Application for a non-material amendment following a grant of planning permission.

Single storey rear extension

62600/APP/2021/783

Removing the original small roof on the rear, revising the bifold door and repositining the roof light

BLOCK PLAN
SCALE:1-200

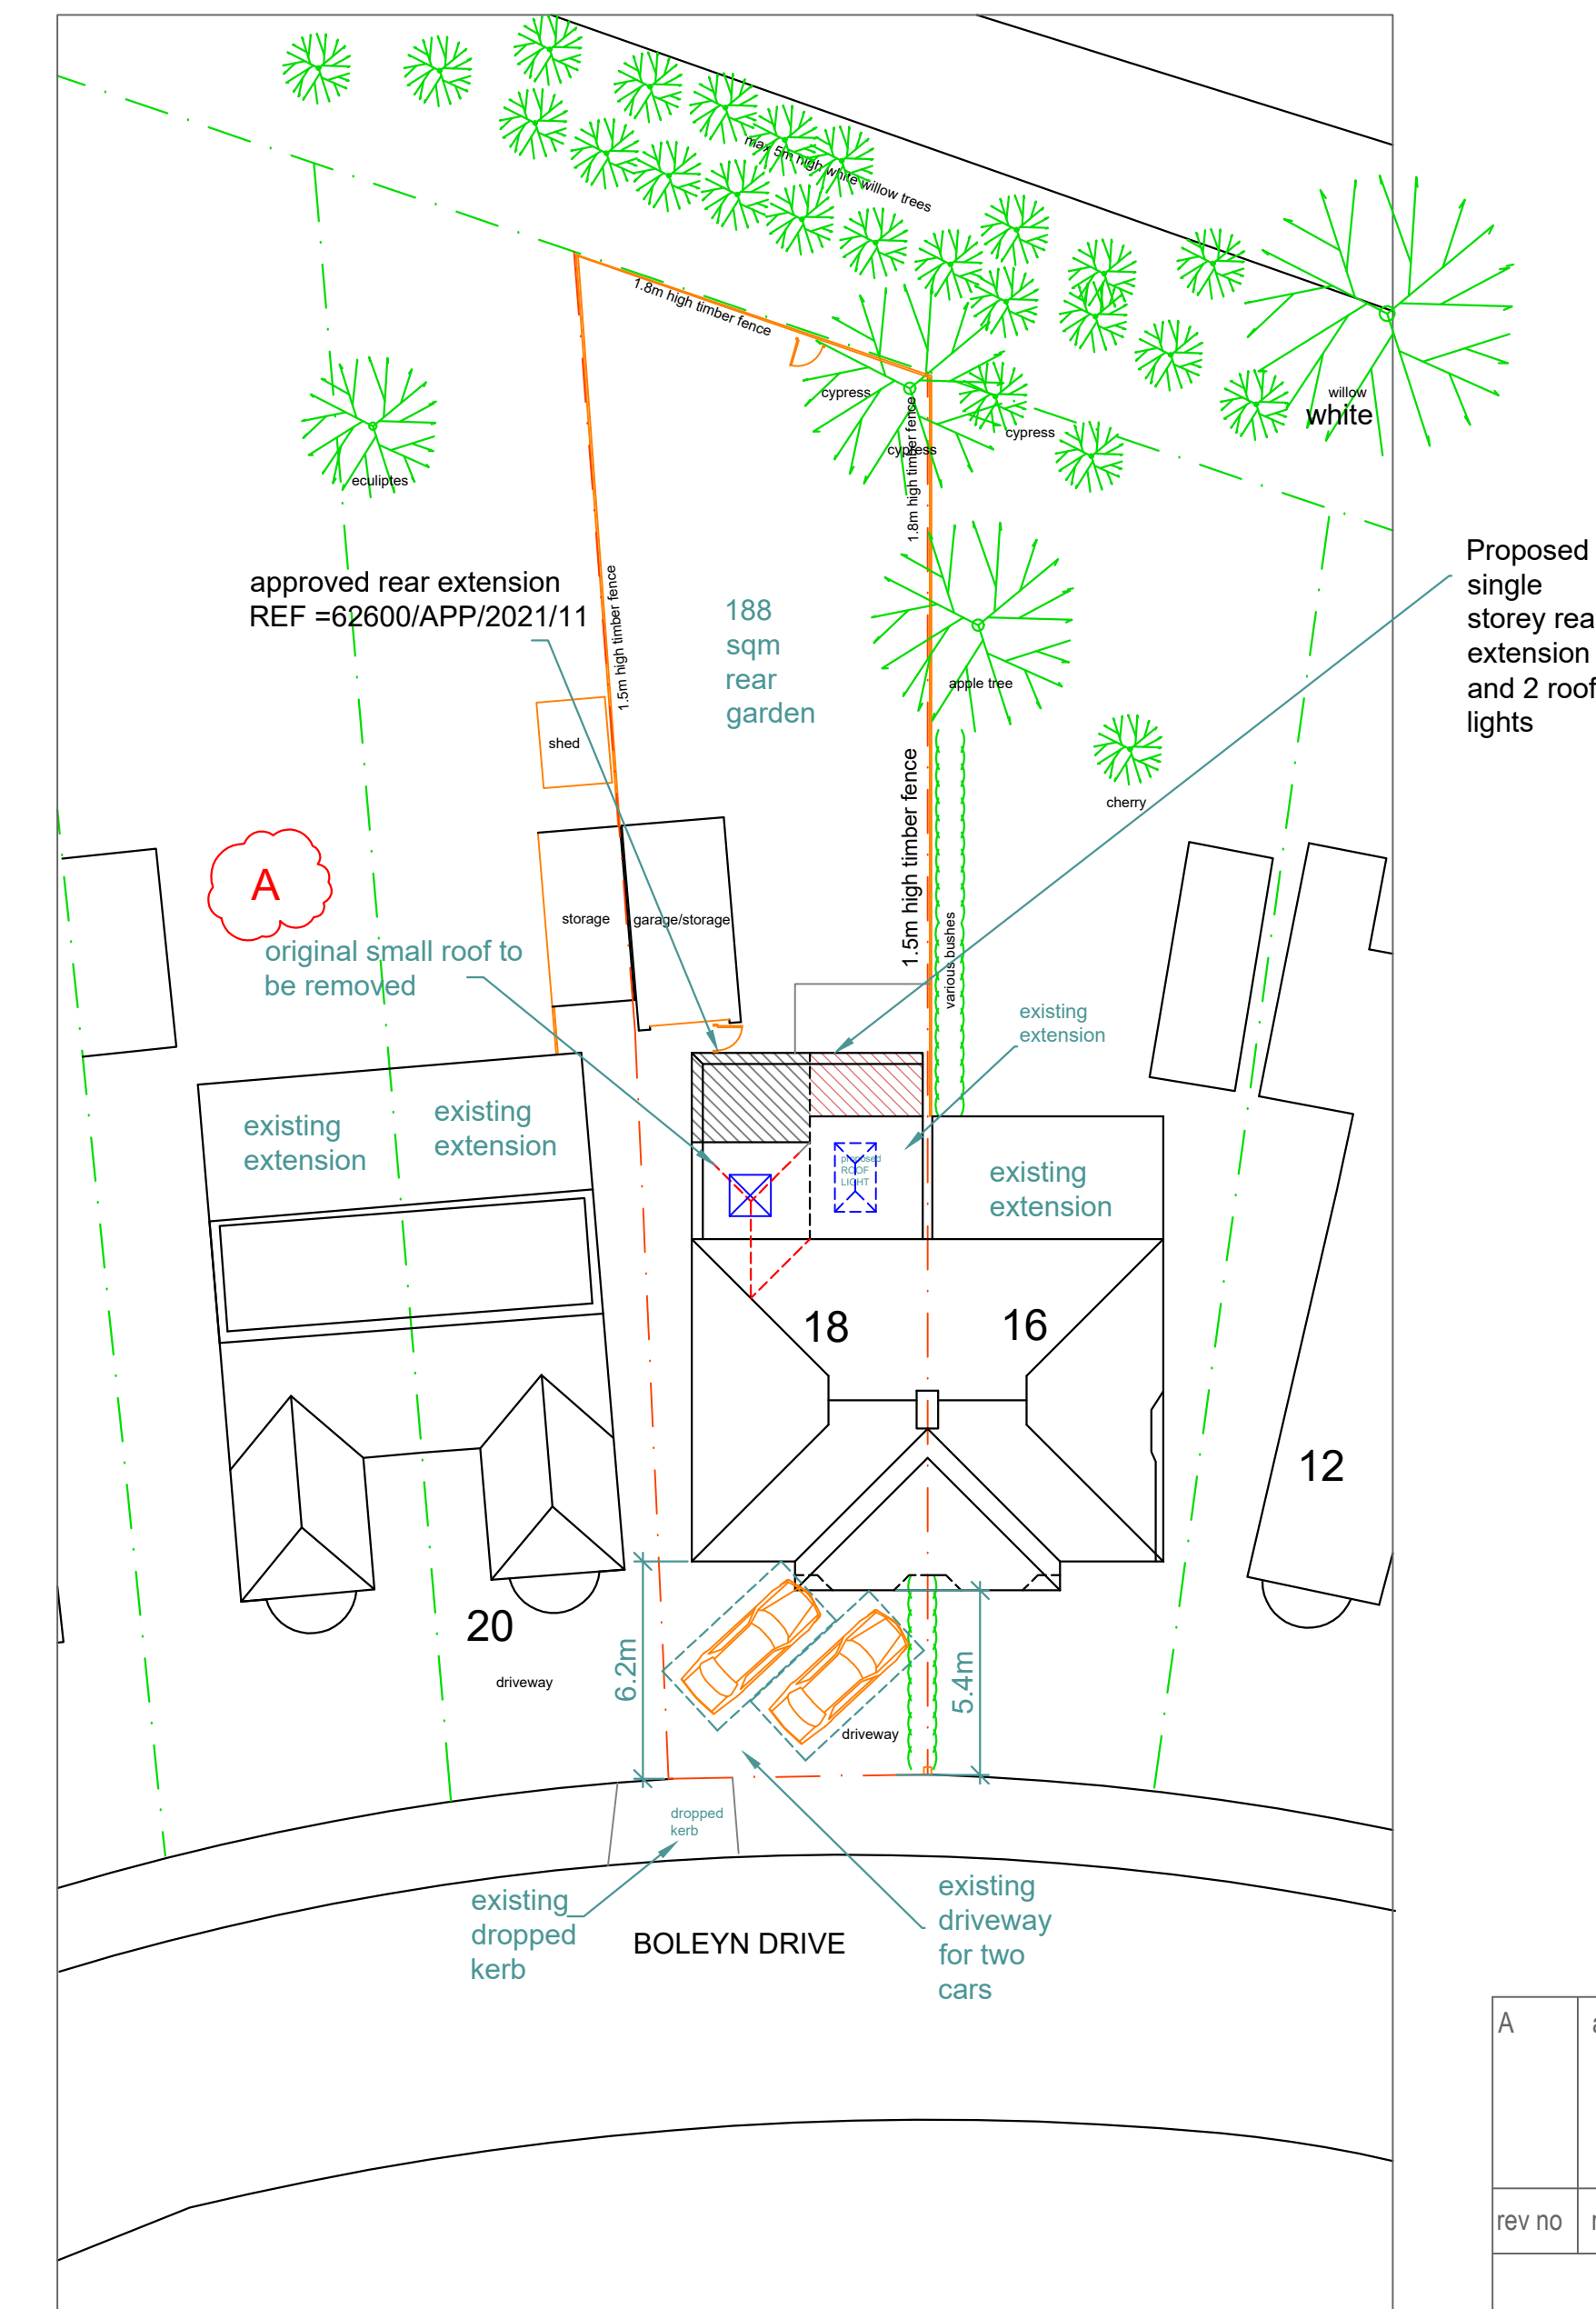
Small roof to be removed to:
1.prevent any water leakage due to complexity of the construction and difficult details
2.make the appearance similar to the adjacent building (they have already removed it)
